From: Tim Townsend <[REDACTED]>
Sent: 17 July 2019 09:33
To: Simon Davis <Simon.Davis@arun.gov.uk>
Cc: Rob Torrance <[REDACTED]>; Andrew Howick <[REDACTED]>
Subject: Cinders Lane DOC app - further information

Further to my comments sent to you yesterday, I have been discussing the matter of the Temporary Traffic Regulation Order (TTRO) and temporary traffic management with County's Local Traffic Officer for the Arun area.

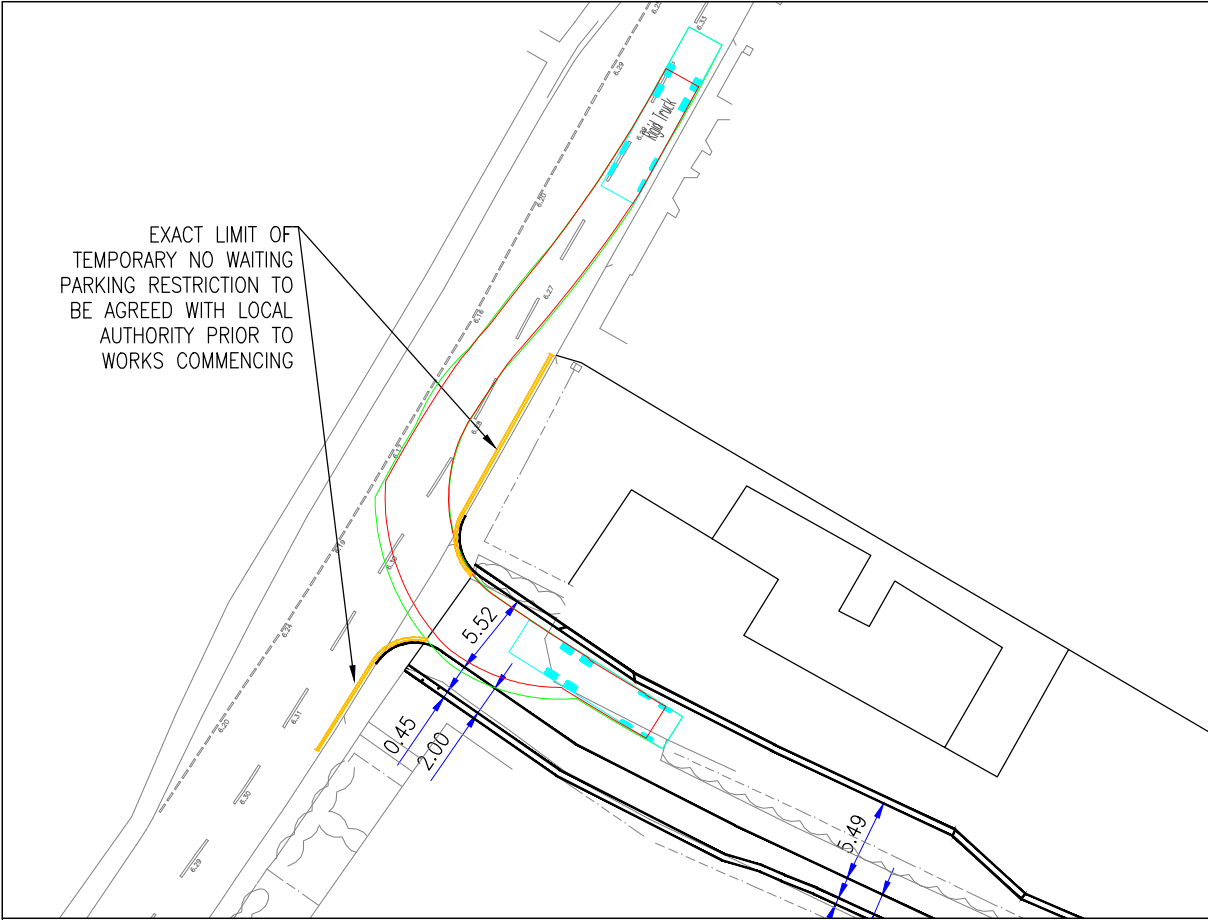
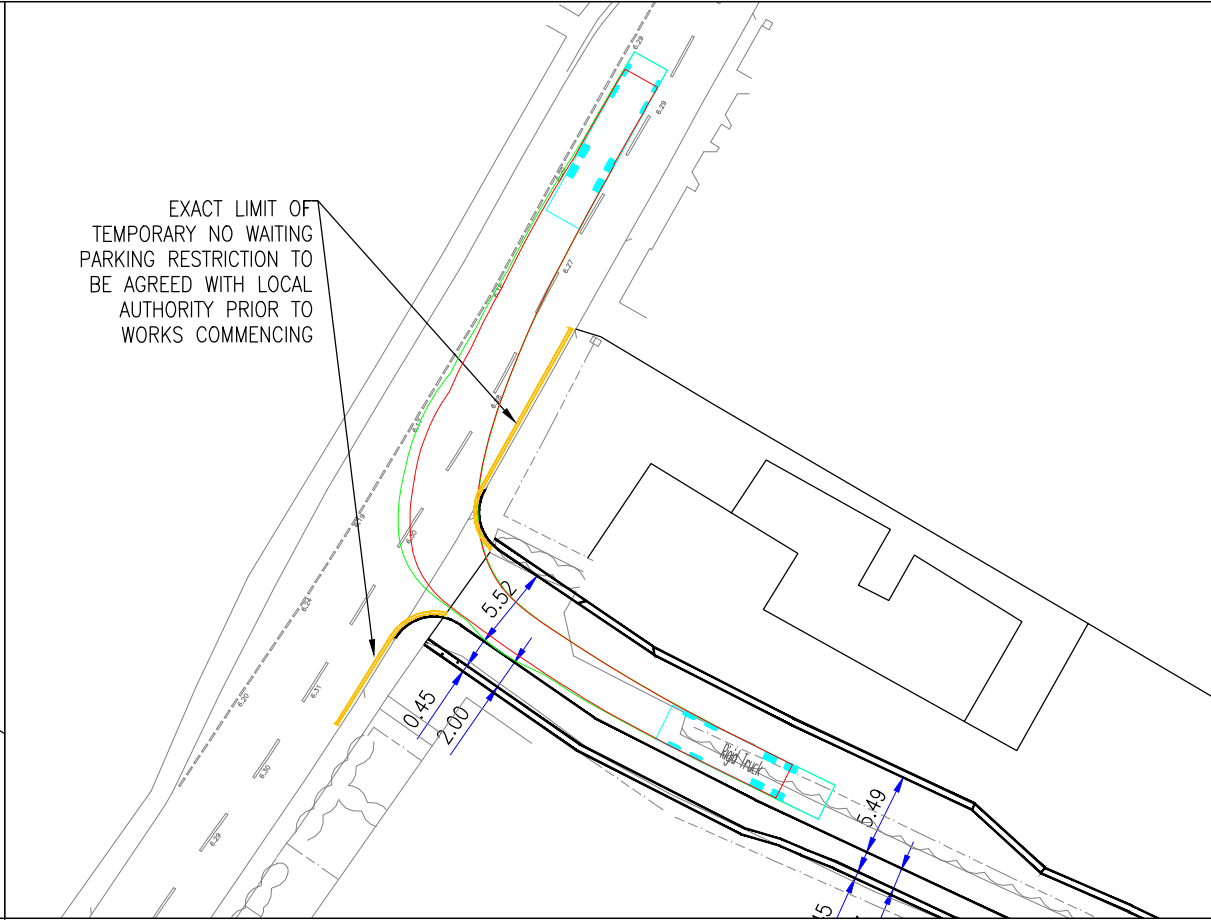
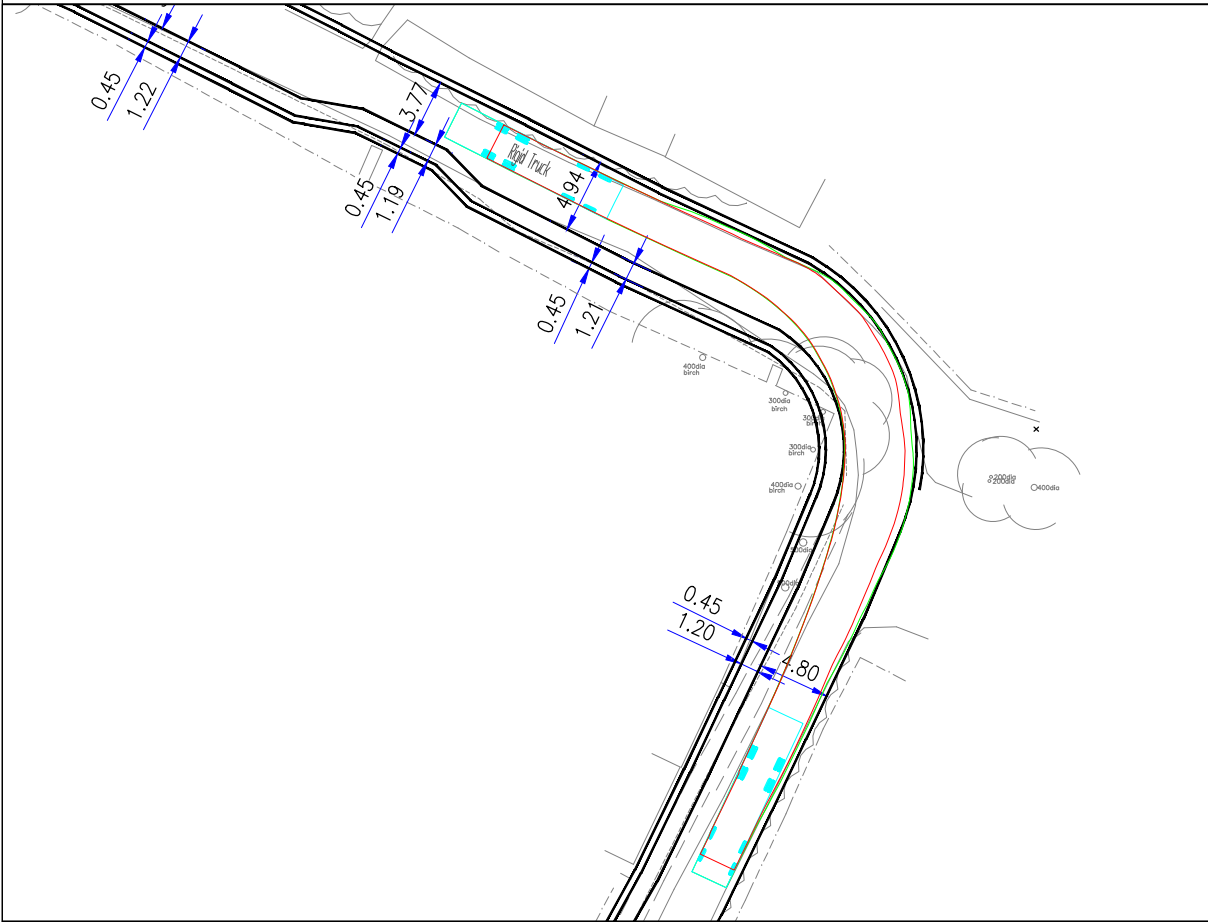
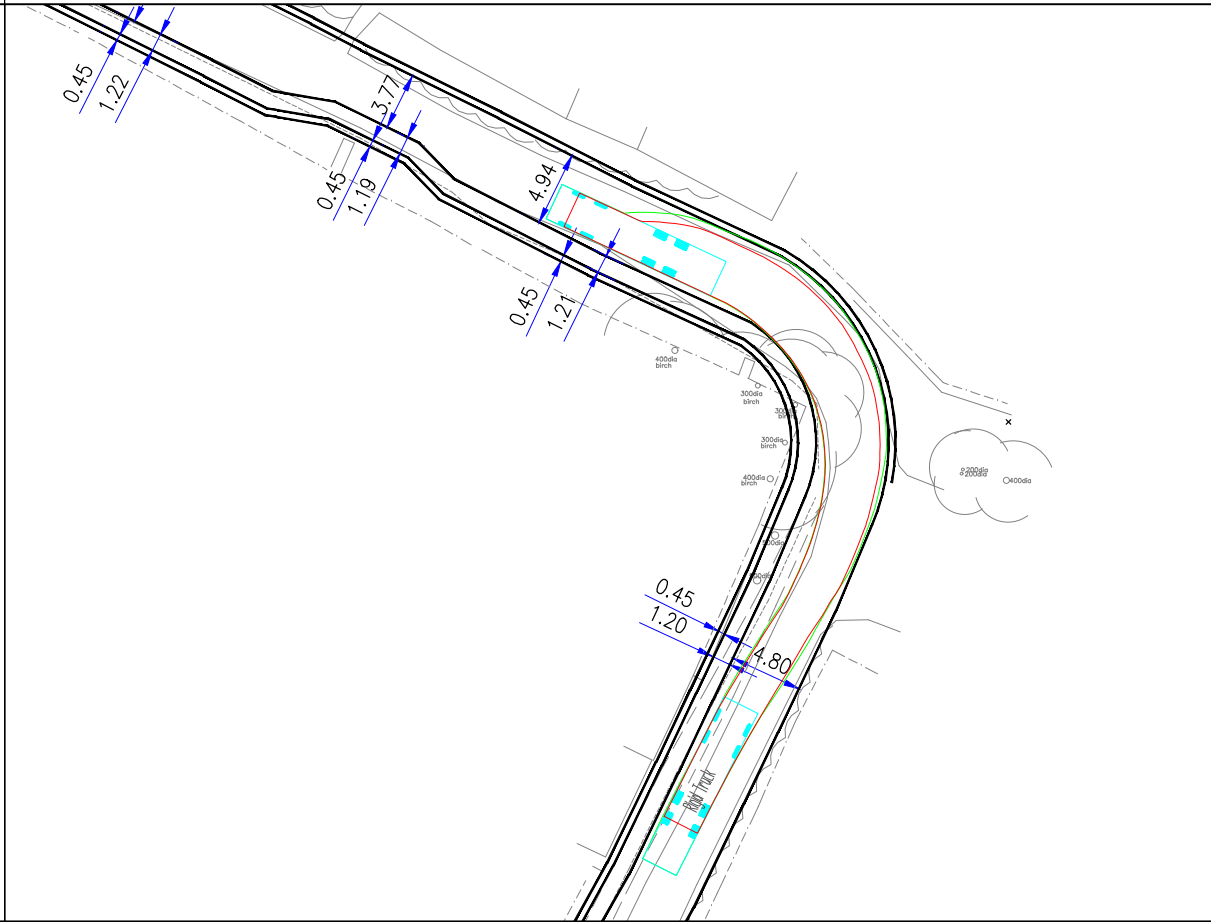
As I have already said, it does appear that temporary waiting restrictions will be required to ensure that large vehicles are able to gain access to and egress from Cinders Lane. The tracking diagrams show that they are needed to the north of the junction, though maybe not for the 25 metre length indicated in the diagram (15m would probably be adequate) and I would suggest that the markings should extend southwards far enough to cover the driveway of 8, Medway Cottages, to ensure that the full width of Cinders Lane is kept clear, so about 6 or 7 metres. However, final details will need to be agreed on-site with the Traffic Officer prior to any works commencing.

County considers that it would be unreasonable to prohibit waiting outside the shop to the north of this junction for the duration of the works, which means that the inevitable presence of parked vehicles will require lorries approaching the site to straddle the centre line of the B2132 Bilsham Road for 40 – 50 metres before reaching the junction. The carriageway is not wide enough to accommodate 2-way traffic as well as the parked cars, so northbound traffic will not be able to pass lorries in this position, so there is a strong likelihood of congestion arising from these local traffic conditions (although congestion does arise here fairly regularly already because of parked vehicles). It is noted that the CMP provides for 2 banksmen to be available in the event that a lorry is required to reverse off site. However, WSCC would like this extended in order to enable lorries to turn into Cinders Lane from the B2132, requiring appropriately qualified people (e.g. banksmen) to be equipped with STOP/GO or STOP WORKS signs, so that traffic can be controlled if conditions require it.

Please would you ensure the CMP is updated to include these commitments.
